Application No: 20/00813/OBL-3

Proposal: Discharge of schedule 2 clause 3.7 of 15/01326/OUT - Open Space Works, Bridleway Scheme, Bridleway Specification and the Management Plan

Location: OS Parcels 6741 & 5426 West Of Cricket Field Nor Wykham Lane Bodicote

Transport Development Control

Drawing Title	
S106 - BRIDLEWAY LAYOUT	
Scale	Sheet Size
1:1000	A1
Date	MAR 2020
Client Ref.	Drawing Ref.
-	2832-4-5
Drawing No.	Status
DR-5700	S4-P1

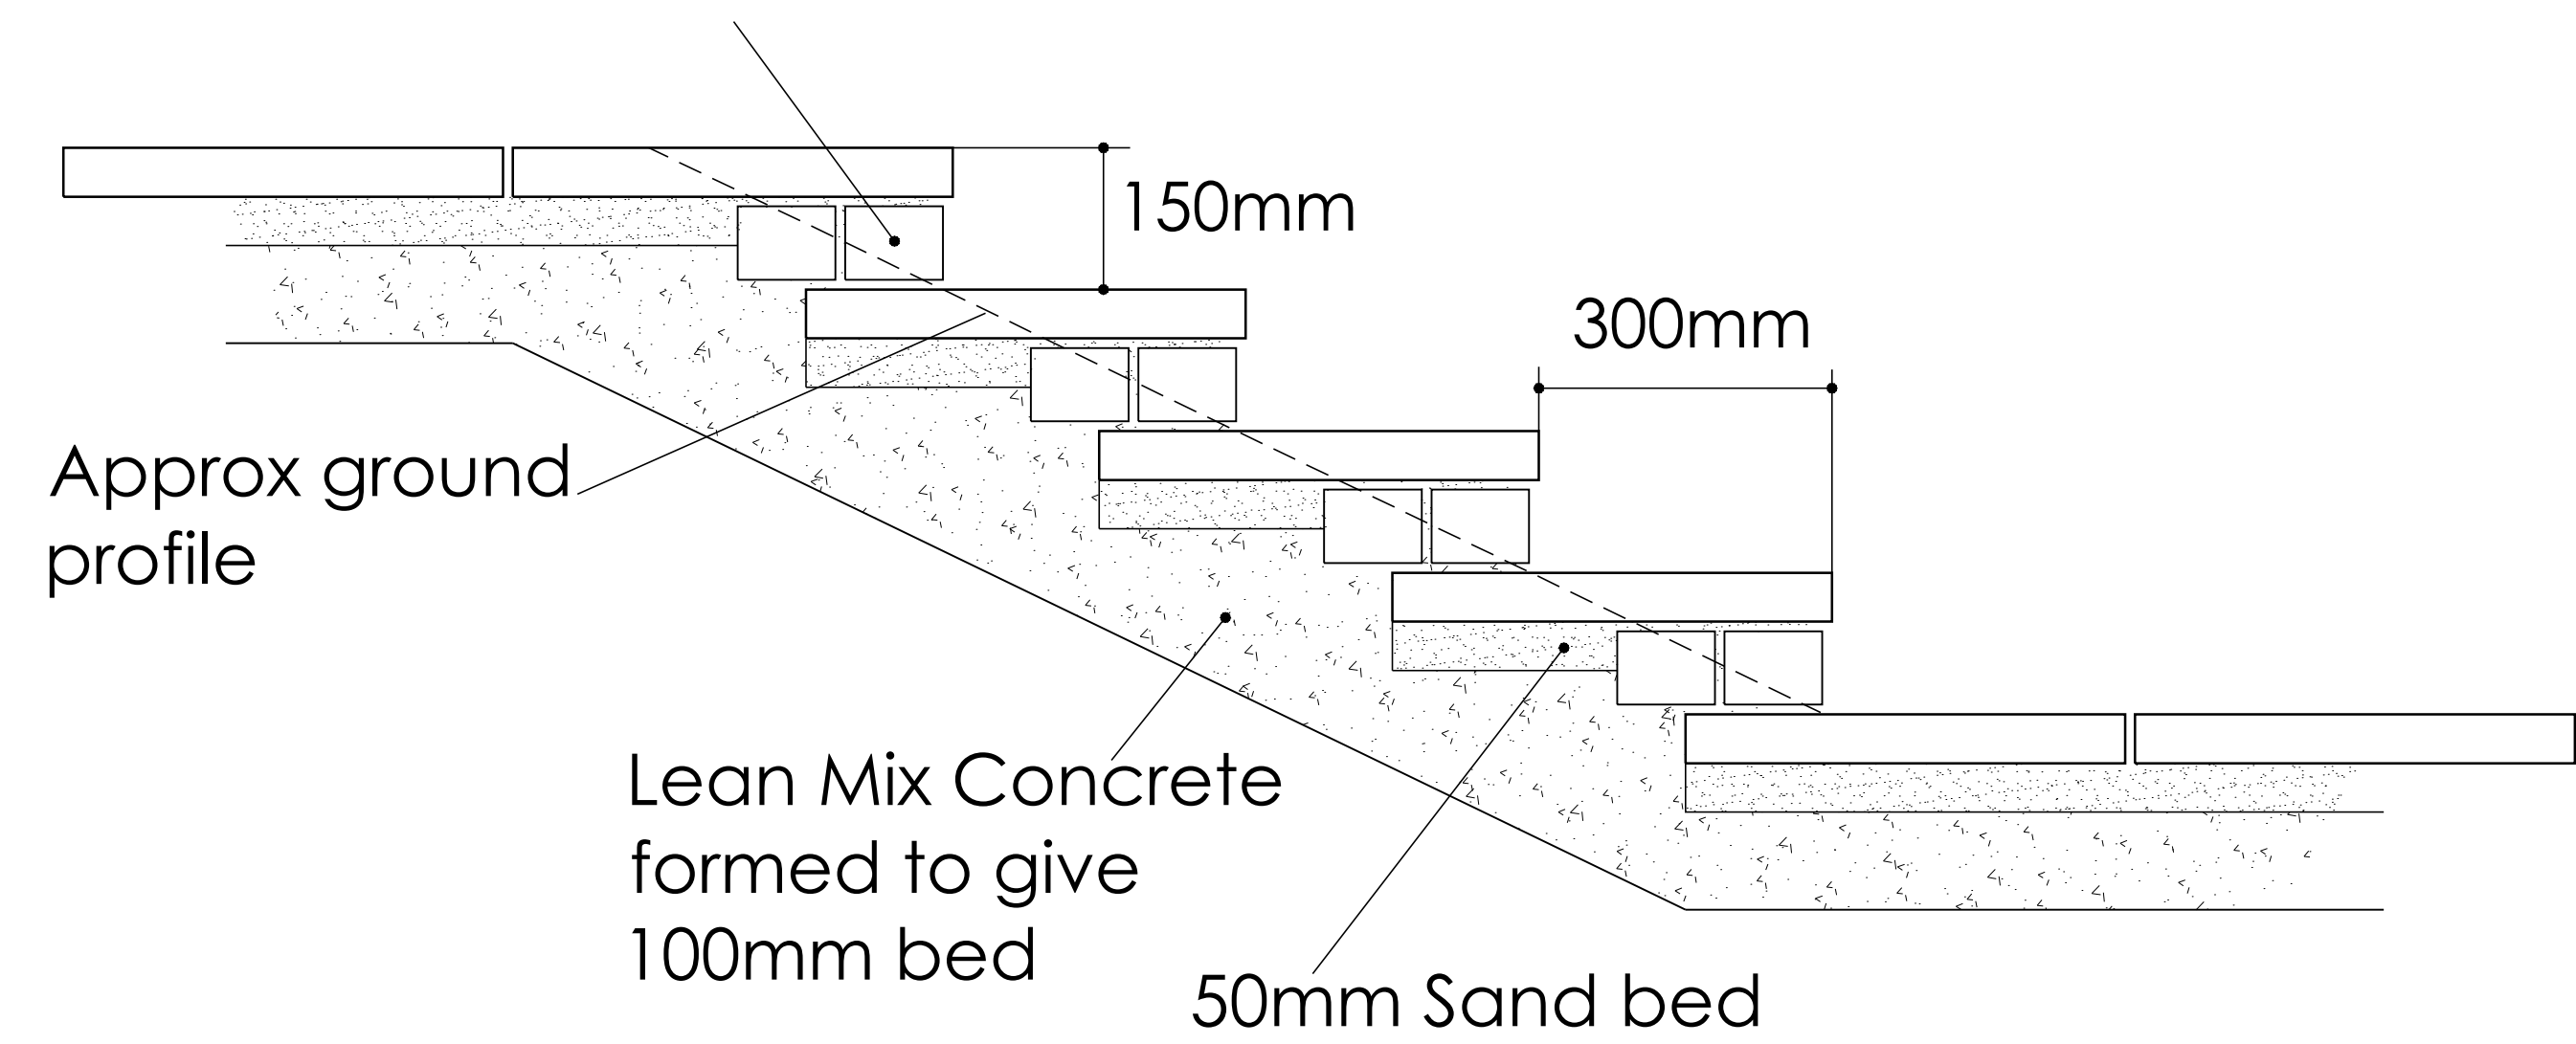
- *The specification does not mention space either side of the bridleway. The applicant should refer to British Horse Society guidelines. 3m is very narrow for a path to be shared with pedestrians and cyclists, as is likely here - 4m is preferred.*
- *There is no detail of the crossing point over the spine road.*
- *There is a pinch point around the edge of the adult football field. Use by equestrians during a football game could be challenging!*
- *The maintenance regime does not specifically mention grass mowing and cutting of vegetation adjacent to the bridleway. Although this is probably picked up elsewhere, it should be included as a requirement of the bridleway maintenance.*

That said, I also notice that the bridleway takes two forms of alignment under different drawings with the notable difference being the routing around the sports pitches. Drwg No: BOD.PL.001S1 Rev D and Drwg No: DR-5700 S4-P1 need to reconcile the bridleway alignment.
